WEST SUSSEX COUNTY COUNCIL CONSULTATION

TO:	Arun District Council FAO: David Easton
FROM:	WSCC Highways - Public Rights of Way
DATE:	5 March 2024
LOCATION:	Land East of Westergate Westergate
SUBJECT:	AL/11/24/OUT Hybrid application consisting of: 1) Outline permission for all matters reserved (except access) for up to 400 No dwellings and associated works and 2) Full planning permission for alterations to site access off Westergate Street and through Pine Close and east-west link road including a bridge over the Lidsey Rife. This application also lies within the parish of Barnham, falls within Strategic Site SD5, CIL Zone 1 (Zero Rated), affects the setting of listed buildings, affects the character and appearance of the Eastergate Church Lane Conservation Area, affects public rights of way. This application is the subject of an Environmental Statement.
DATE OF SITE VISIT:	n/a
RELEVANT PUBLIC RIGHTS OF WAY NUMBER(S):	Footpaths 296, 297, 298, 300, 317

RECOMMENDATION:	Objection
S106 CONTRIBUTION TOTAL:	TBC

Figure 6.4: Public Rights of Way (PROW) (LV-0004)

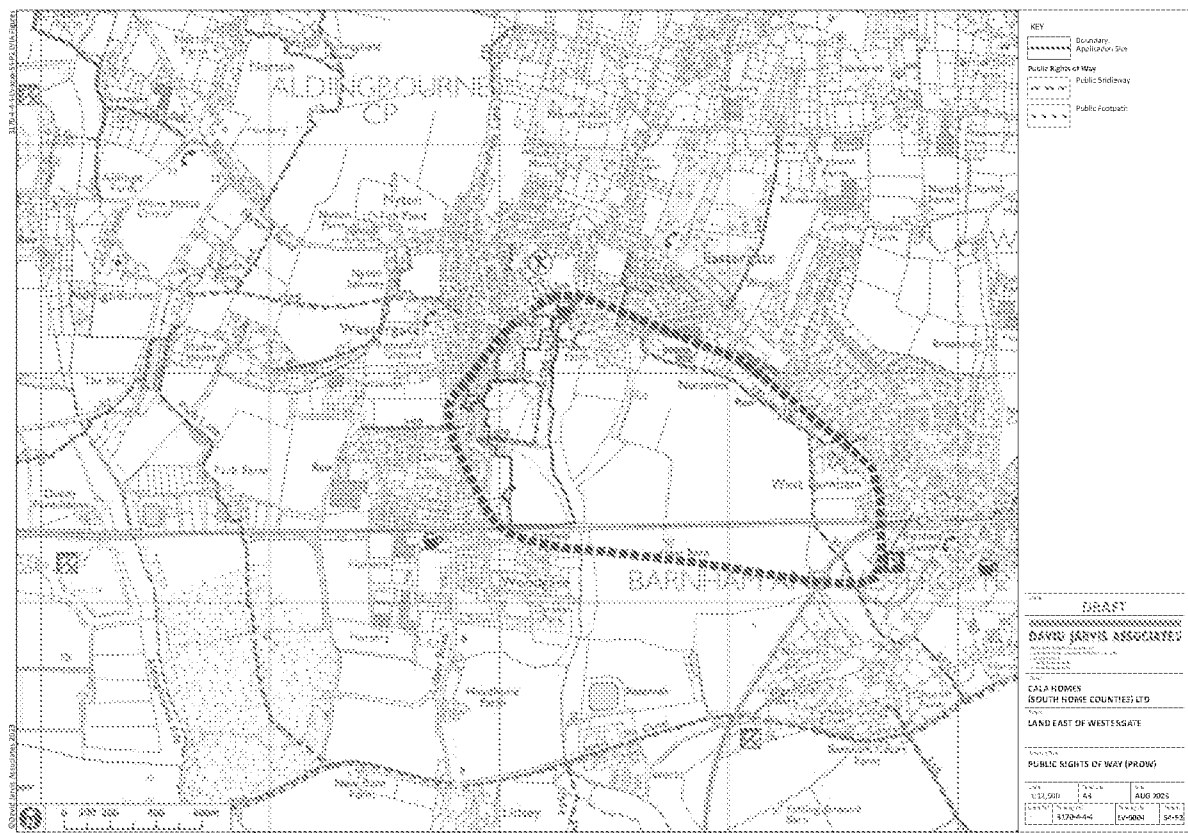
The Public Rights of Way (PRoW) this site affects are identified but not always shown on their definitive lines, it is unclear if some fall within or just outside the site's boundary, there appear to be diversions but no mention is made of these and there are contradictions across different plans and

documents as to what is proposed. Without clear details, I have to object and request more information.

Footpath (FP)296

I cannot see any indication of the route of this footpath in the Overall Sketch Layout however the Framework Travel Plan states FP296 will be upgraded. What route will the footpath follow? Do you plan to divert it? What upgrade is sought? Is it intended to allow cycling on a permissive basis over the footpath or upgraded to a Bridleway that will cater for cycling and equestrian use as well as pedestrian?

Will the path cross the main east-west road? If so, what crossing facilities are proposed?

Footpath (FP)297

FP297 carries the higher status of a Highway maintainable E-path through the site and will require Highways input therefore.

- it appears necessary to divert FP297 to accommodate the planned access arrangements,
- a north-west corner appears to be cut off,
- the FP may be upgraded as a proposed cycle and pedestrian route.

Footpath (FP)298

Again it appears this footpath will be diverted and upgraded but without any details provided.

Footpath (FP)300

This path appears to remain on its current definitive line but is extended. Is it intended that this extension will be offered up for adoption to secure it in perpetuity?

Footpath (FP)317

It is unclear from the Overall Sketch Layout and the Planning Statement if the whole of this FP falls within the site's boundary. The Framework Travel Plan states this FP will be upgraded but no further details are given.

Please submit details and plans clearly indicating;

- where the definitive lines of existing PROW lie within and outside of the site,
- where diversions are sought and what routes these will follow,
- if extensions are to be offered for formal adoption, and
- what upgrades are planned.
